Reference: JM, DR; 17/28/0004

***RE: WALGETT SOLAR FARM PROJECT (SSD 8095) - NOTICE OF EXHIBITION***

Walgett Shire Council has given consideration to the Environmental Impact Statement (EIS) for the proposed Walgett Solar Farm that is currently being publicly exhibited by your agency.

Figure 3: Recorded Heritage Sites

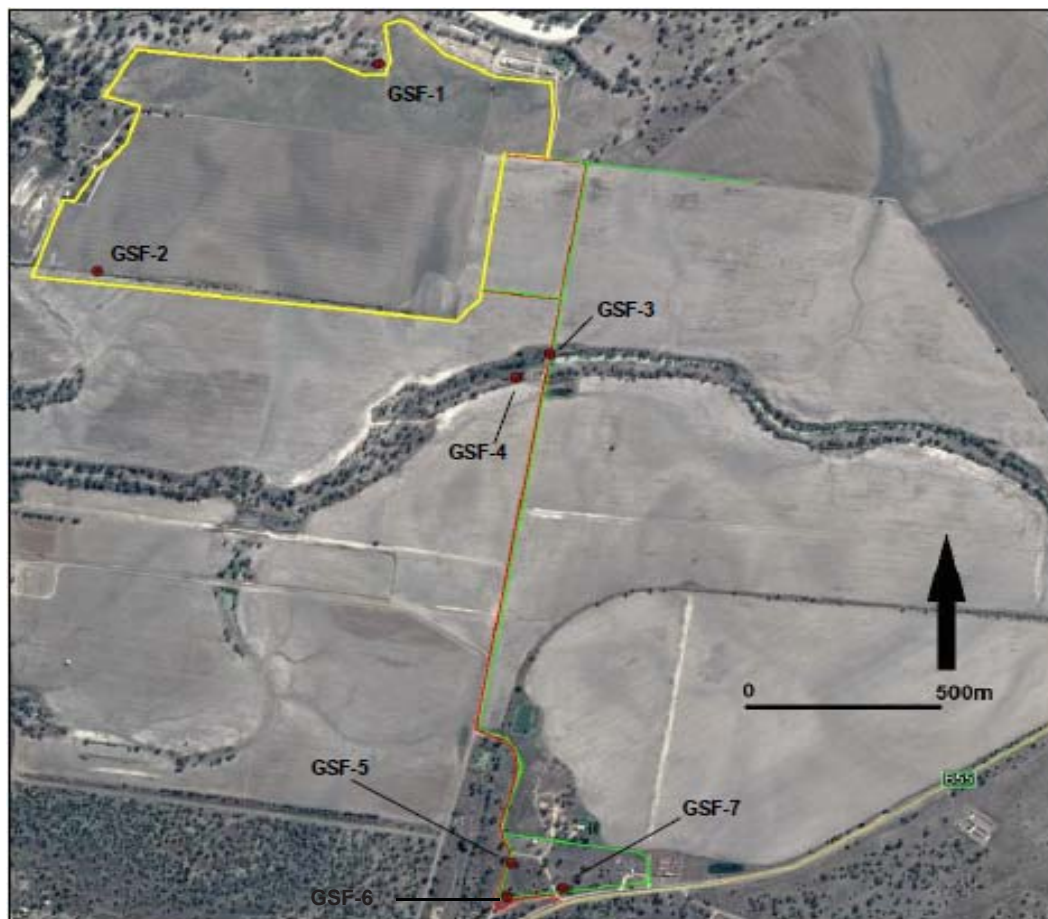
- Walgett Shire Council's notes that the chosen allotment for the development:
  - Do not have direct access to the Essential Energy Zone substation in relation to other allotments;
  - may lack safety in regards to access to the Castlereagh Highway and this should be considered in any traffic development and management plans;
  - May be of Aboriginal heritage and there may be undiscovered Aboriginal artifacts and other items located on the allotment.
